Appeal Decision

Appeal Ref: APP/R5510/W/21/3276492

102 Hunters Grove, Hayes UB3 3JF

1. The appeal is allowed and planning permission is granted for a two storey side extension with alterations to front and porch to front to form a 1-bed dwelling house at 102 Hunters Grove, Hayes UB3 3JF in accordance with the terms of the application, Ref 47772/APP/2020/4054, dated 7 December 2020 and subject to the attached schedule of conditions.

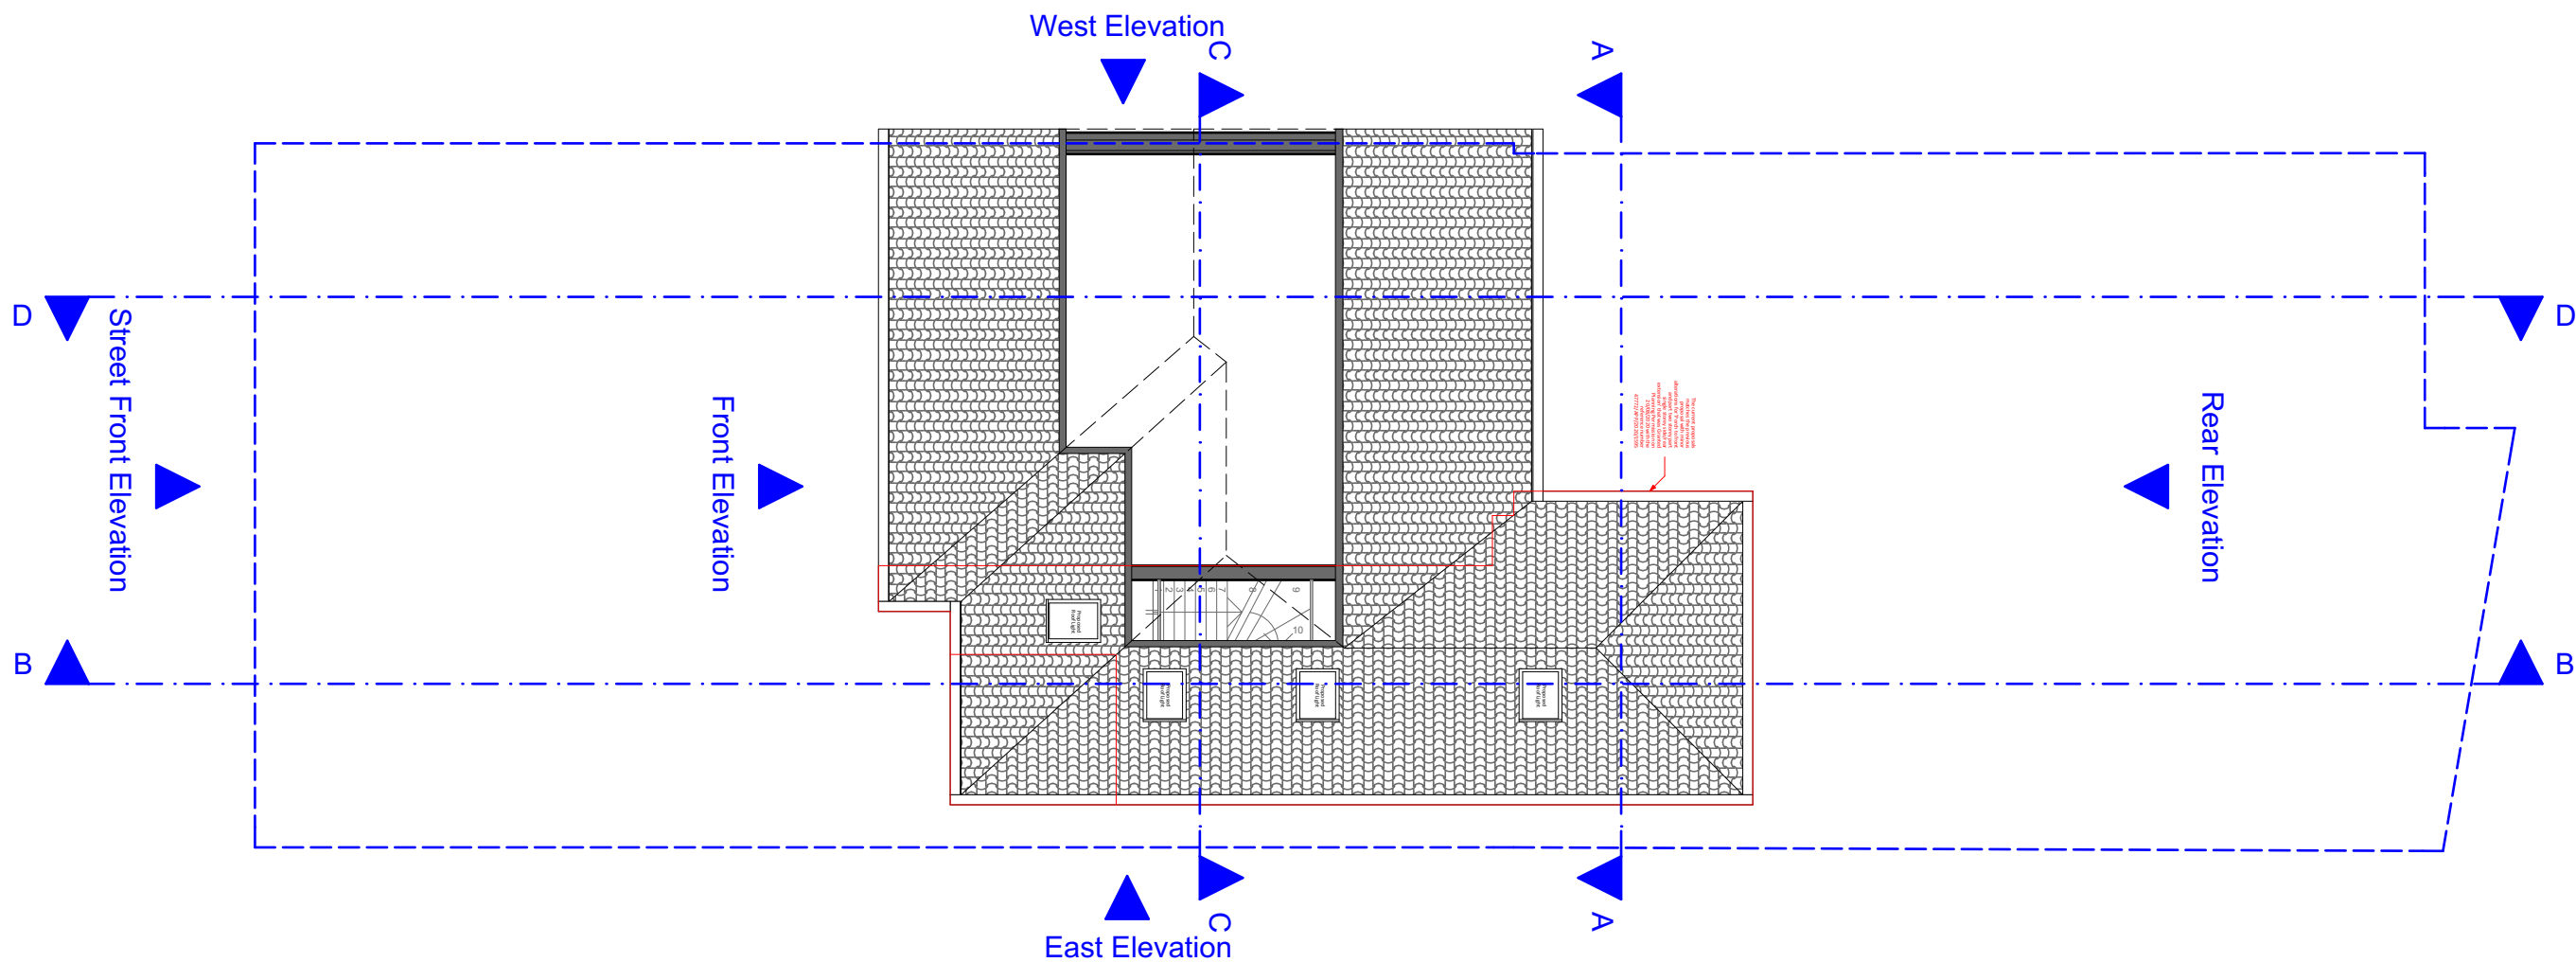
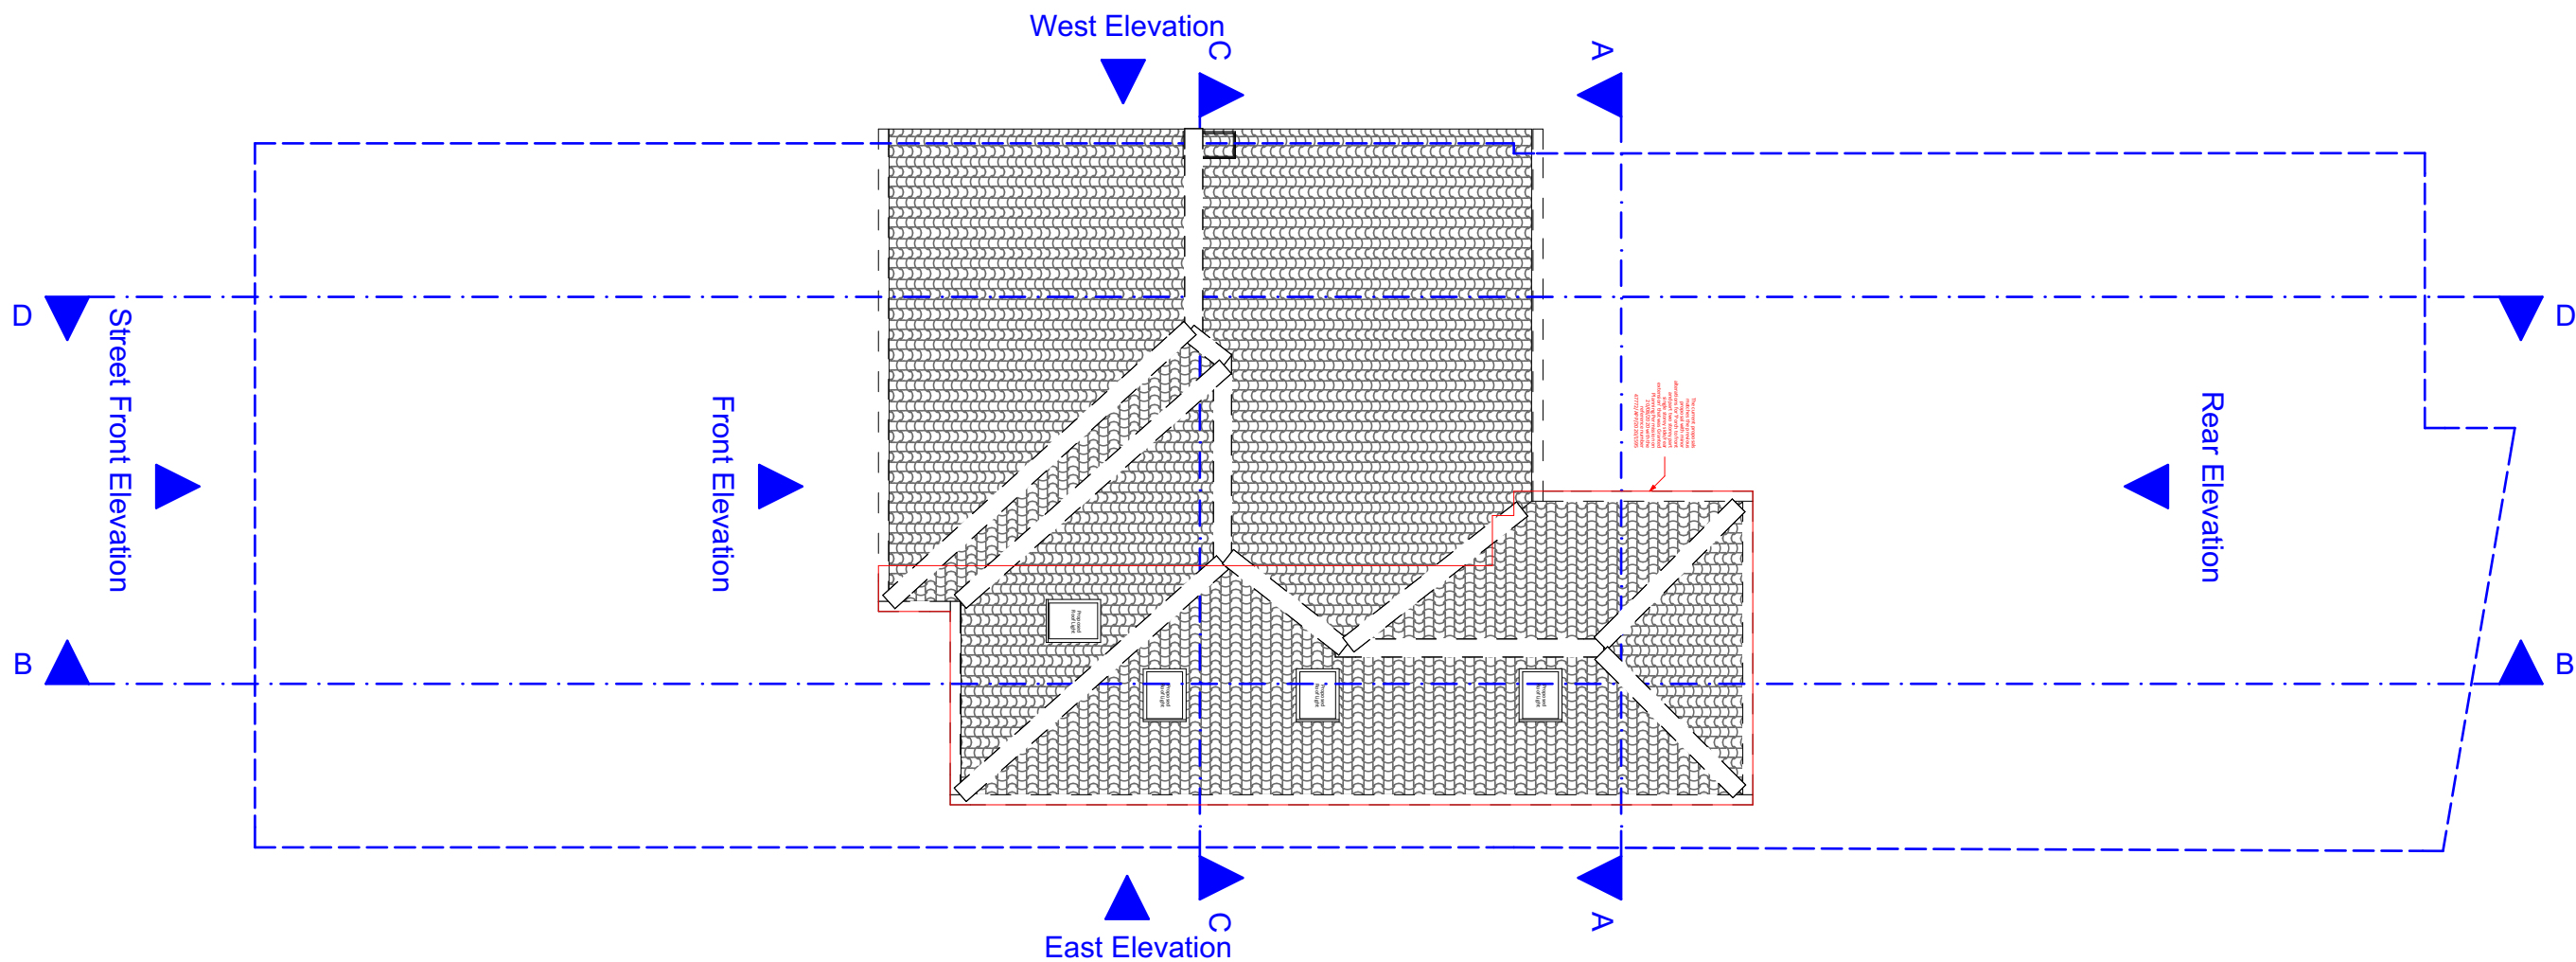
6. The Council takes the view the proposed dwelling would only have a GIA of 55 sqm, excluding the loft space. Conversely, the appellant states the GIA would be 59.5 sqm across the ground and first floor, thus excluding any contribution from the loft space. In the submitted plans, the floor area of each of the rooms across the two floors has been provided and the Council has not sought to identify any specific errors in this respect. While the floor areas would be some 57.7 sqm, they would omit any space taken up by the internal partitions within the dwelling which the LP, DMP and NDSS all note should be included in the GIA. Consequently, when taking account of the partitions, it is reasonable to find that the GIA would exceed 58 sqm.

7. In light of the above, there would be acceptable living conditions for the future occupants of the proposed development with regard to the provision of internal space. Accordingly, the proposed development would meet the GIA requirements of LP Policy D6, DMP Policy DMHB 16, and the NDSS.

Proposed Street Front Elevation

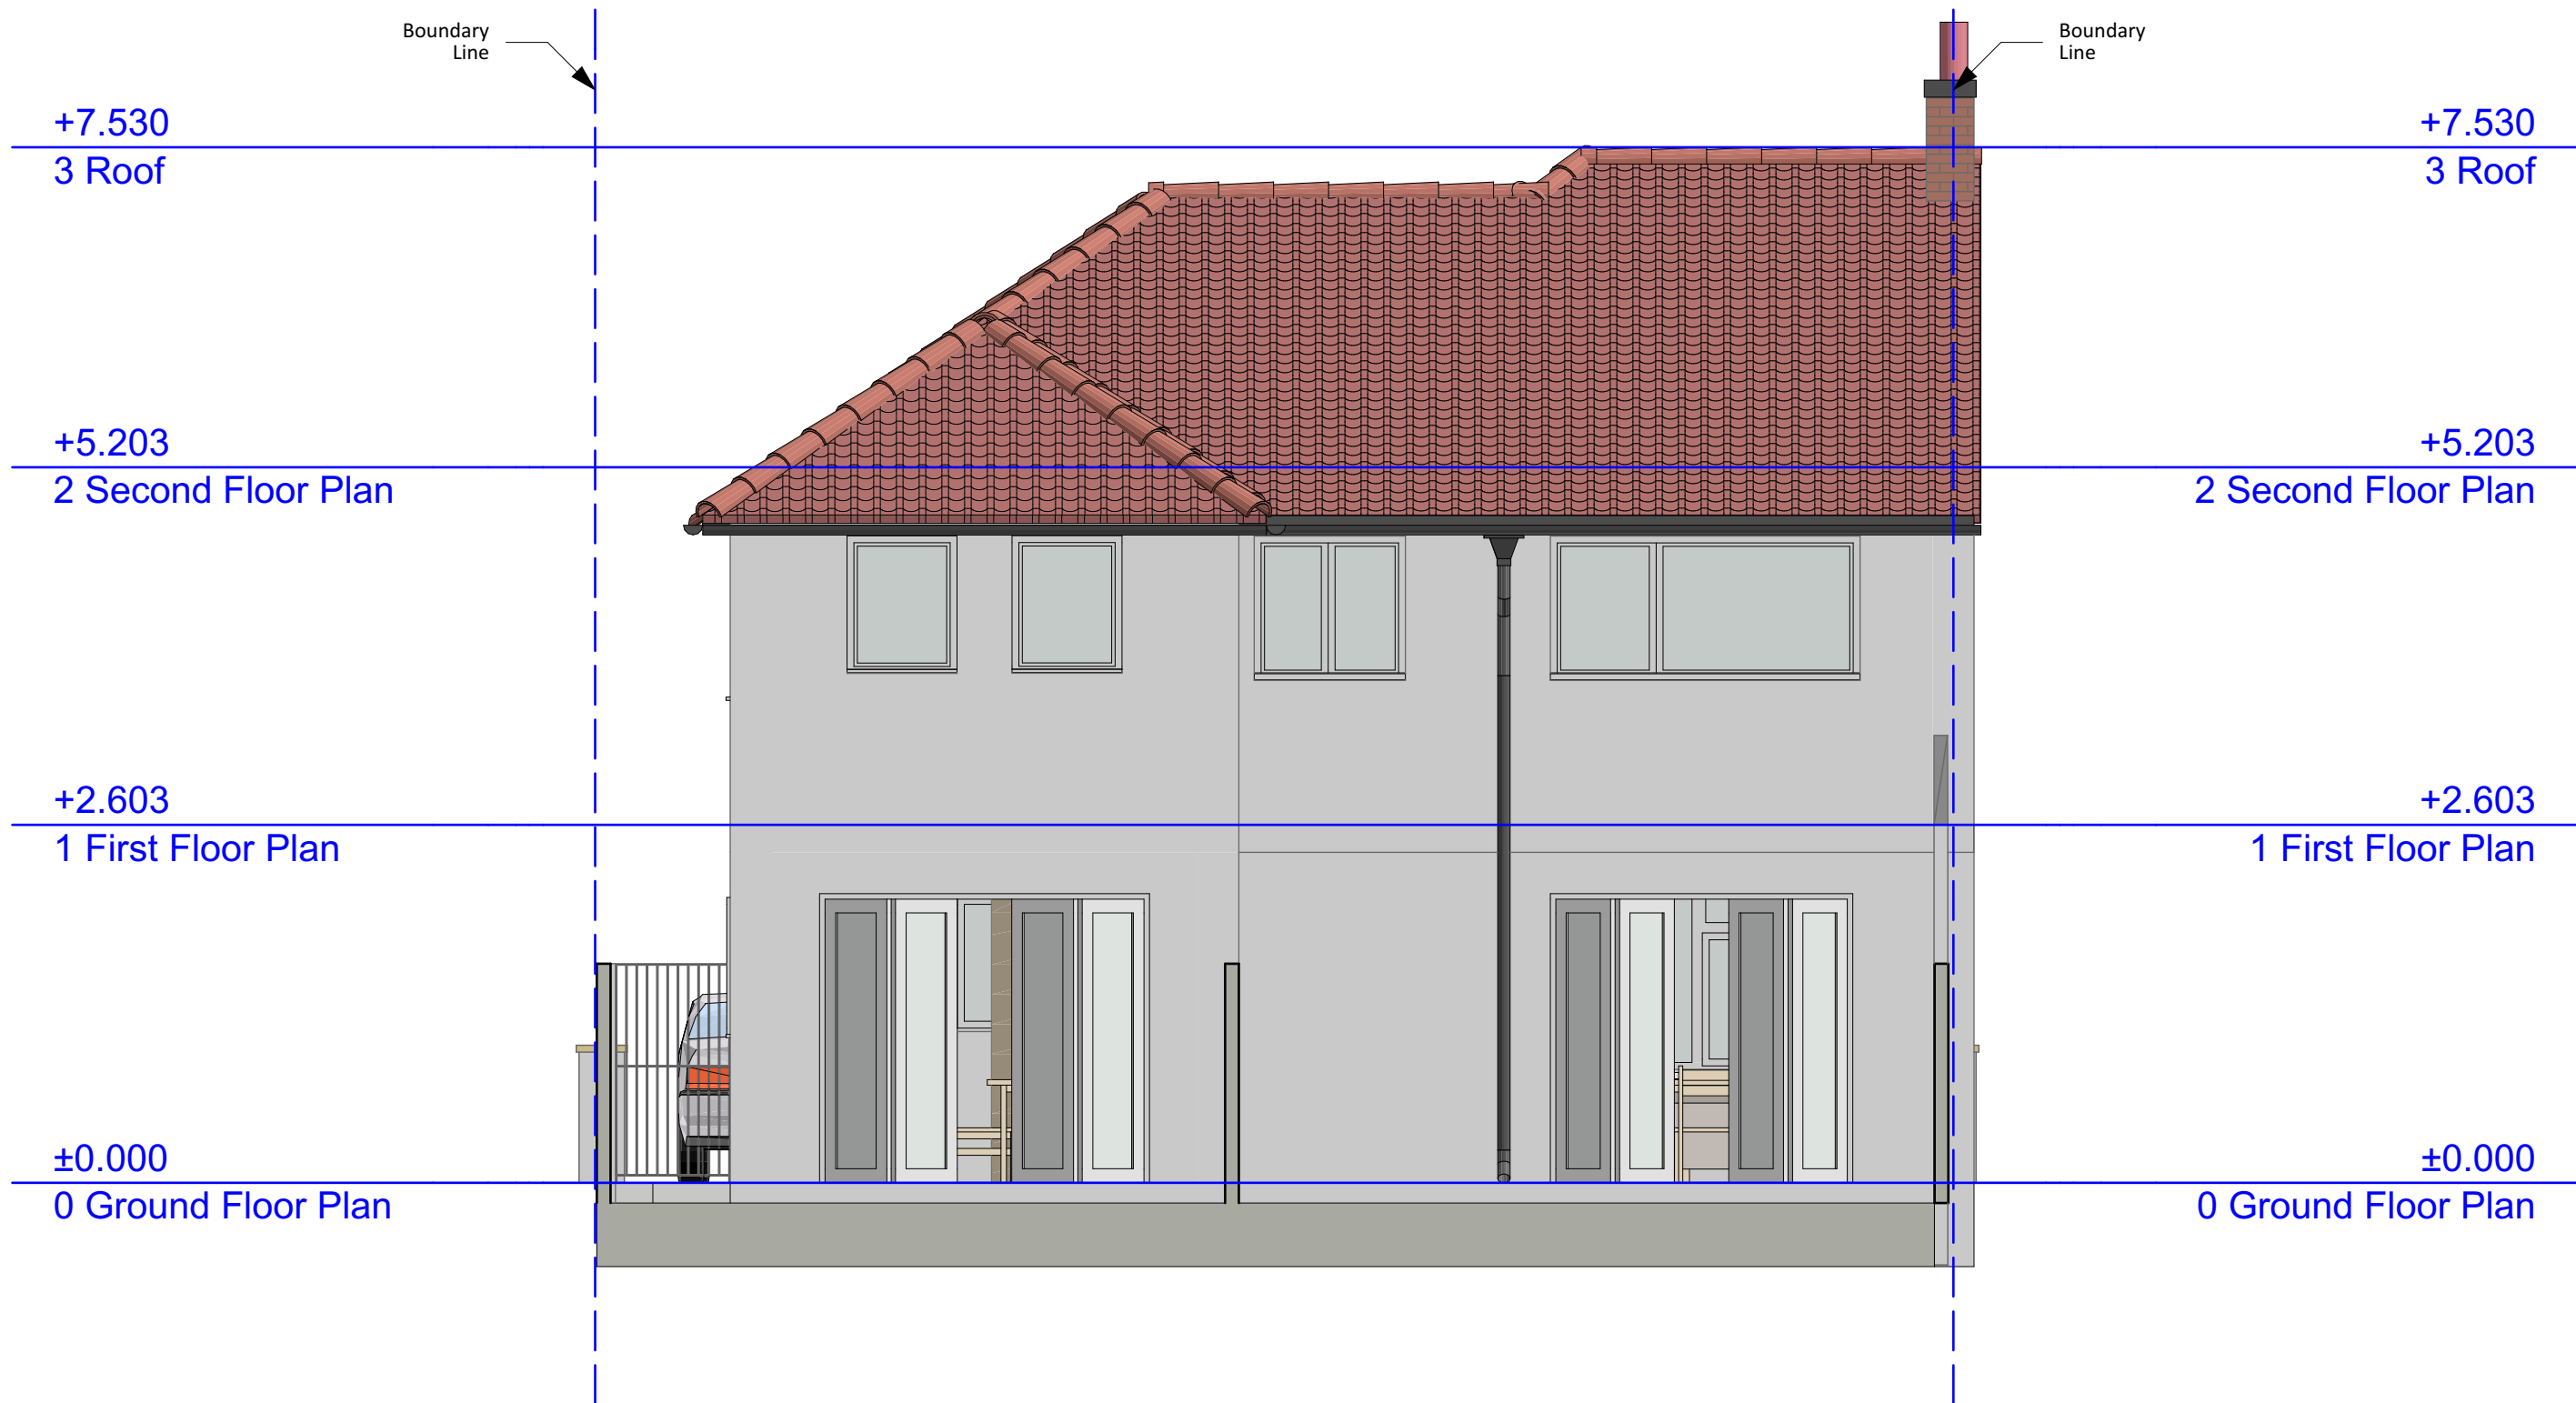
9. In the proposed scheme, the existing hedge would be removed and replaced by a low wall. A new hedge would be planted along the south east boundary adjacent to an existing boundary wall, while there would be new shallow planting strips in front of the proposed new dwelling and partly in front of the existing house. The planting strips would largely lie behind the proposed bin stores.

11. Due to its location, proposed 0.5m height and narrow nature, the proposed hedge would have a very limited positive effect on the surrounding street scene. The contribution would certainly be more limited than that of the

existing hedge. Moreover, the proposed planting strips would largely be hidden from public view by the proposed refuse storage and car parking.

12. While the scheme was previously amended to move the bin stores away from the front boundary, they would be sited directly in front of the existing house and the proposed development, and would face the street. As such, they would remain visually prominent and obtrusive. Furthermore, in order to avoid visual clutter and given the new dwelling would have a pathway to the side leading to its rear garden, the new dwelling's refuse storage should ideally be located within its rear garden, unless there is clear justification for not doing so.

13. As there would be inadequate soft landscaping and the bin stores would be unduly prominent, the proposed development would not comply with Policies DMHB 11 and DMHB 14. However, in the event of the appeal being allowed, one of the conditions suggested by the Council requires the submission and approval of a landscape scheme, which would include details of soft landscaping and refuse storage. Additionally, the appellant has not objected to the Council's suggested conditions. The Framework sets out that decision makers should consider whether otherwise unacceptable development could be made acceptable through the use of conditions, and a landscape scheme would enable the deficiencies identified above to be addressed.

- 4) No development above damp proof course level shall take place until a landscape scheme has been submitted to and approved in writing by the Local Planning Authority. The scheme shall include:

1. Details of Soft Landscaping
 - 1.a Planting plans (at not less than a scale of 1:100)
 - 1.b Written specification of planting and cultivation works to be undertaken

- 1.c Schedule of plants giving species, plant sizes, and proposed numbers/densities where appropriate
 2. Details of Hard Landscaping
 - 2.a Refuse Storage

2.b Means of enclosure/boundary treatments
